# CITY OF ALBUQUERQUE

Planning Department  
Brennon Williams, Director

**Re: My Little World**  
**303 Old Coors Road SW**  
**Traffic Circulation Layout**  
Architect's Stamp 04-21-2021 (K11-D091)

Based upon the information provided in your submittal received 07-01-2021, the above referenced plan cannot be approved for Building Permit until the following comments are addressed:

AS104

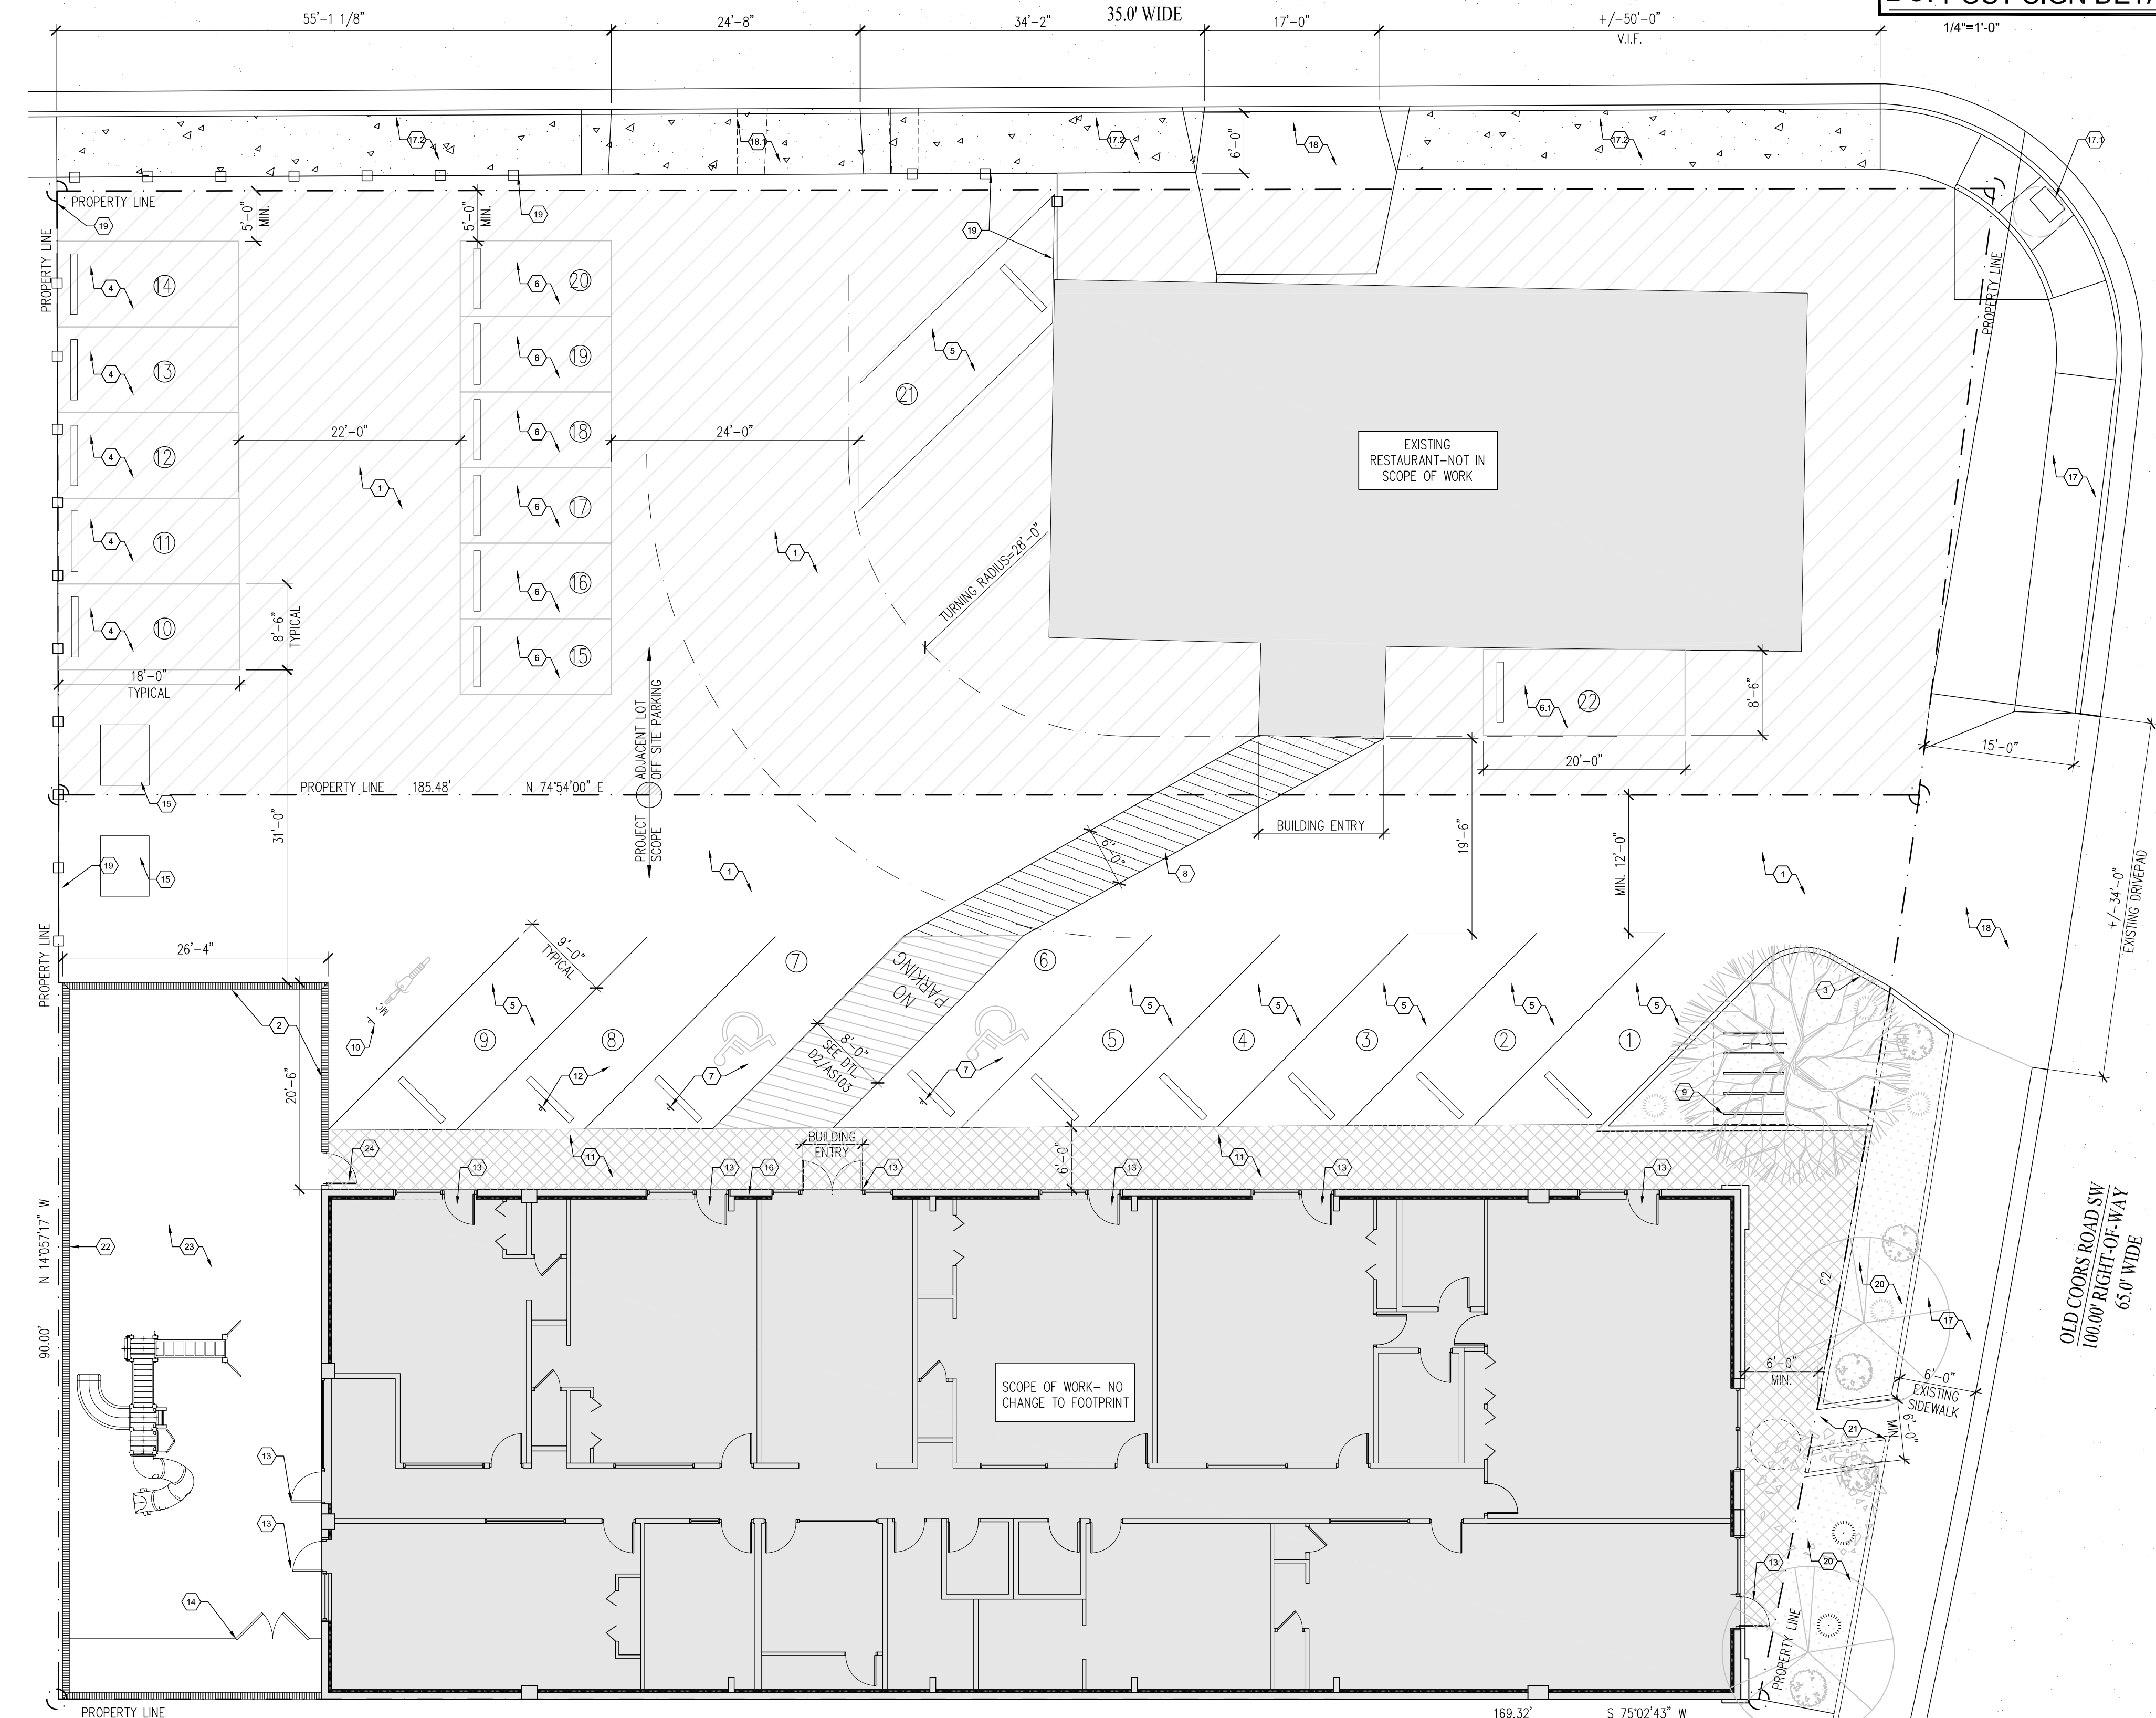
6. **Referenced to D4/AS100 but no sheet AS100 has been provided. Please clarify.**
7. Identify all existing access easements and rights of way width dimensions (IF APPLICABLE).

AS103

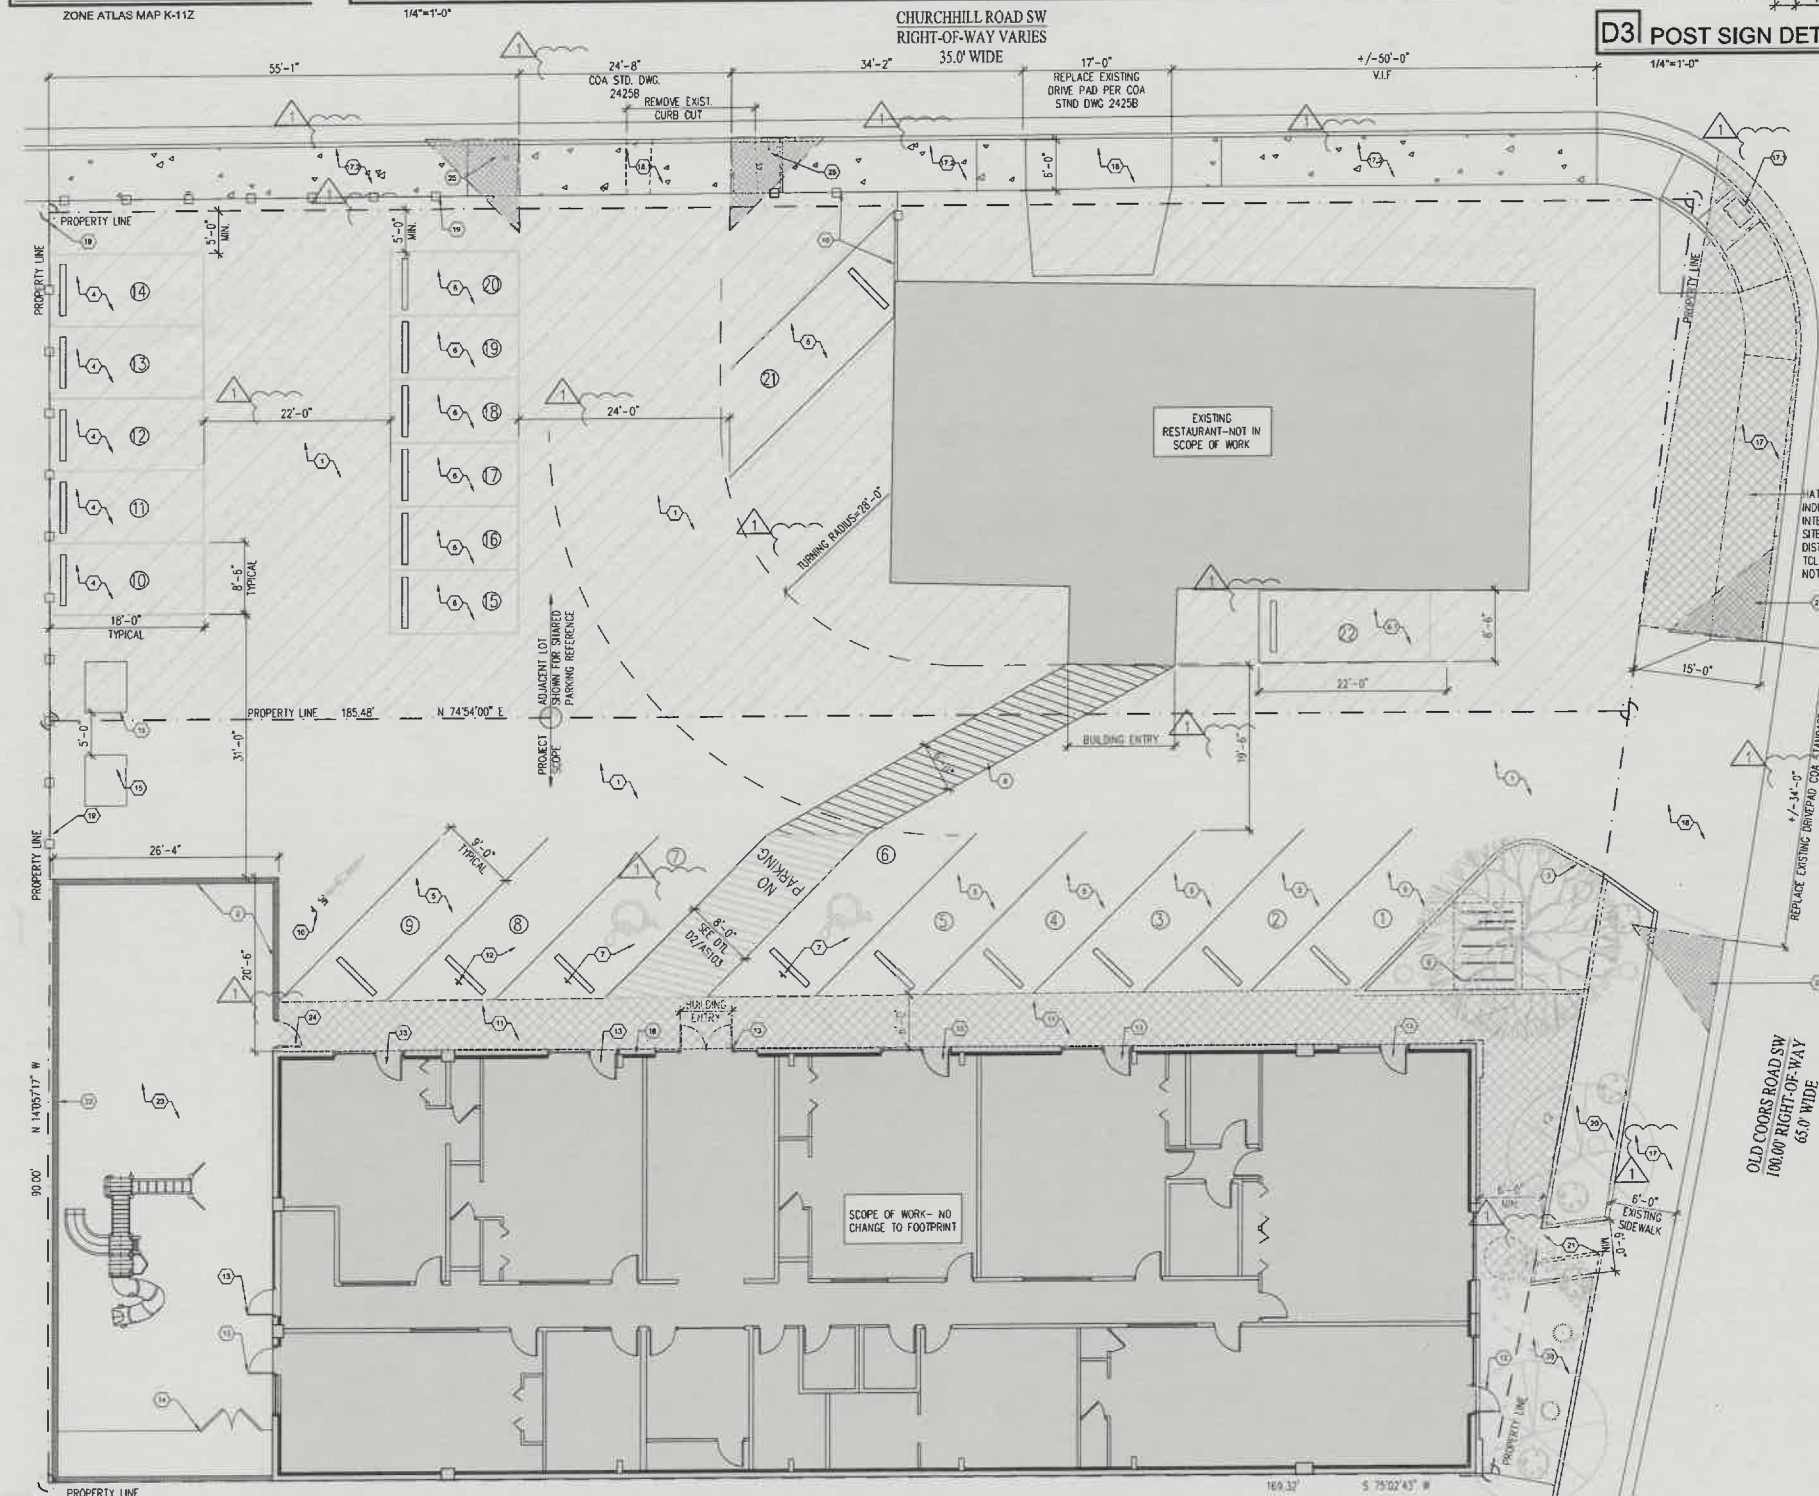
- The proposed diagonal parking stalls are encroaching into the drive aisle and driveway pathway. This is cause a traffic safety concern since maneuvering out of stall will occur on COA ROW. This type of backing out onto COA ROW is not acceptable. Please address this traffic concern. The FD needs 20 ft for their vehicles and the aisle width is only 12 ft in width (Obtain FD concurrence with proposed drive aisle widths thru out site).

5. Keyed notes 18 is shown as existing drive pad off Old Coors frontage but it is placed on sidewalk between Keyed notes 21 and 20 fronting the main roadway. Please clear up this concern of misplaced note.

10. Old Coors Drive is a **Minor Arterial**. The existing driveway width +/- 34 ft. There are already problems with the parking stall layout not matching the existing width and the FD requirements for the drive aisle width of 12 ft. Please address this **traffic safety/hazard** for ingress movements of southbound Old Coors Drive.
11. Please list the width and length for all existing and proposed parking spaces. Some dimensions are not shown.
12. The minimum parking stall dimensions are:

13. The existing Restaurant doesn't have any ADA parking stall. Status? Since you are providing all **NEW PARKING STALLS FOR THIS SITE**
14. The ADA accessible spaces must include an access aisle. **Van Accessible aisles should be 8 ft width, all others 5 ft wide. It appears from the plan that it is 6 ft wide.** Please clarify.

- 29. Provide all pavement markings details for proposed pathway from existing restaurant entrance to adjacent proposed building entrance. It can't be blue as stated on keyed note 4.
